**Director General's Requirements
Kooragang Island Bulk Liquids Storage Facility Project
Project Application No: 07_0044**

Director-General's Requirements

Project	Construction and operation of a bulk liquids storage facility and associated infrastructure
Site	Greenleaf Road, Kooragang Island
Proponent	Marstel Terminals Newcastle Pty Ltd
Date of Issue	26 April 2007
Date of Expiration	26 April 2009
General Requirements	<p>The Environmental Assessment must include:</p> <ul style="list-style-type: none"> • an executive summary; • a detailed description of the project including the: <ul style="list-style-type: none"> – need for the project; – alternatives considered; and – various components and stages of the project; • consideration of any relevant statutory provisions; • a general overview of the environmental impacts of the project, identifying the key issues for further assessment, and taking into consideration the issues raised during consultation; • a detailed assessment of the key issues specified below, and any other significant issues identified in the general overview of environmental impacts of the project (see above), which includes: <ul style="list-style-type: none"> – a

Neighbouring Industry and Location of Proposed Pipeline

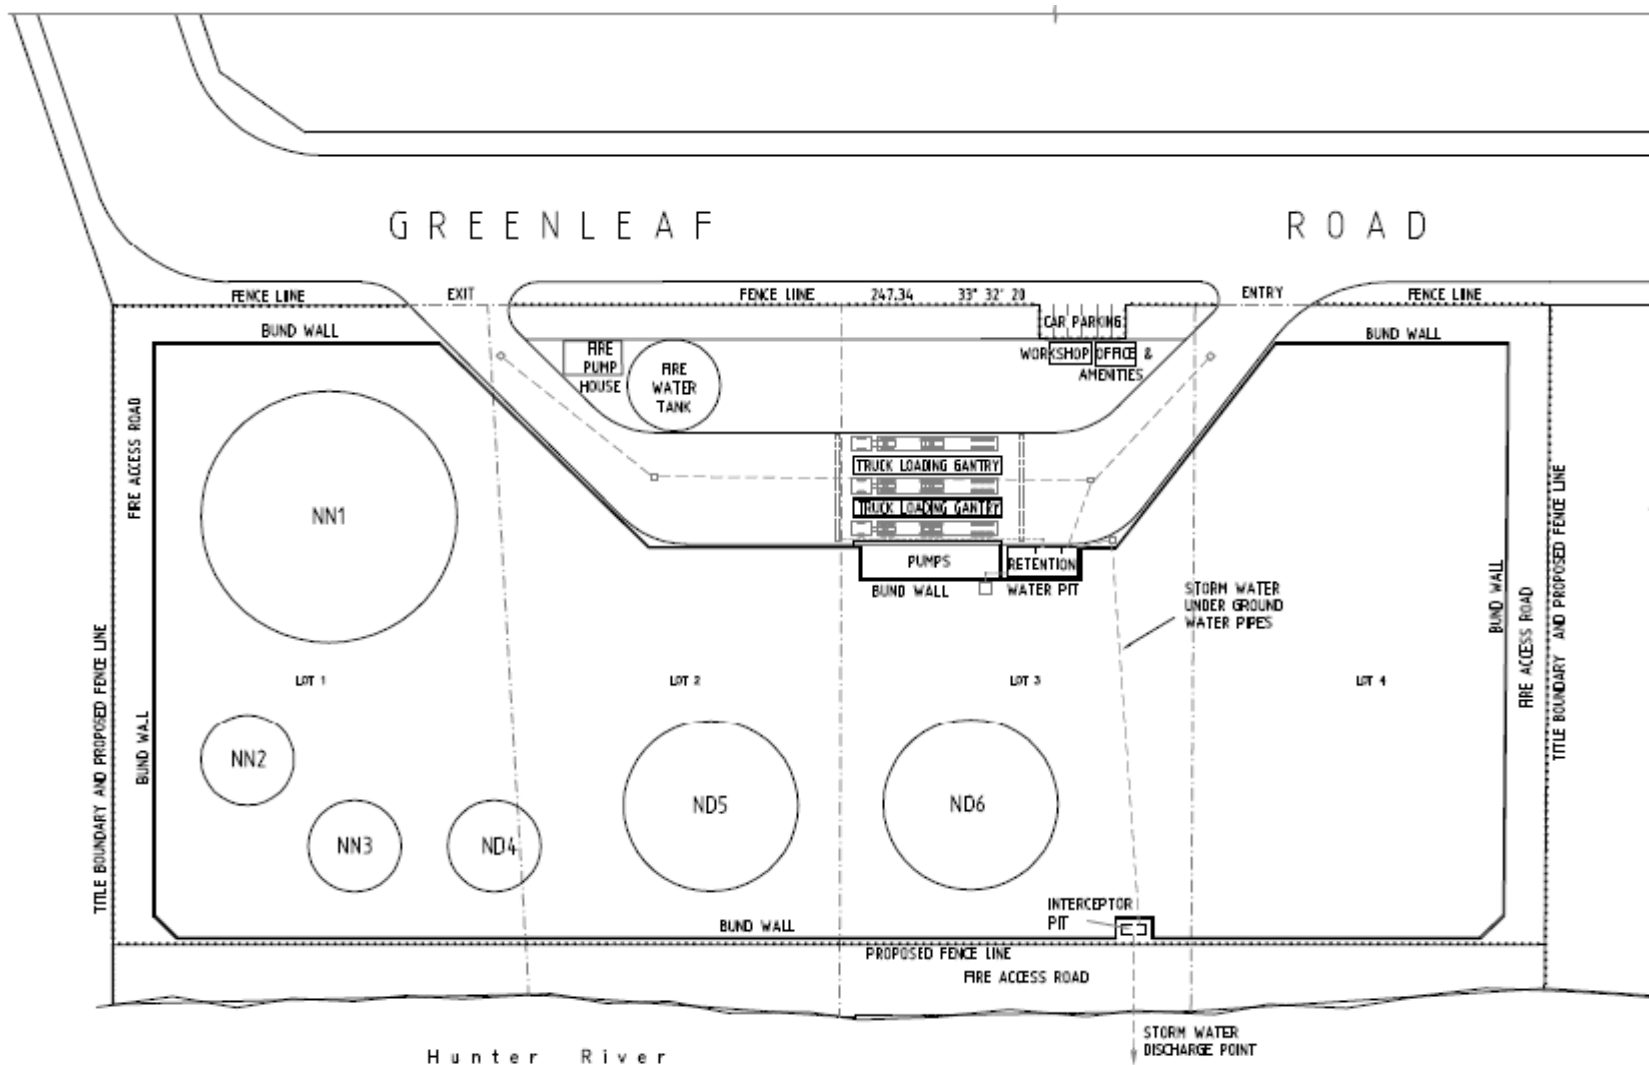
Demonstrate compliance with the relevant requirements of the Newcastle Development Control Plan 2005. In this regard, the proposed carparking layout indicated on the site plan F3 is not satisfactory.
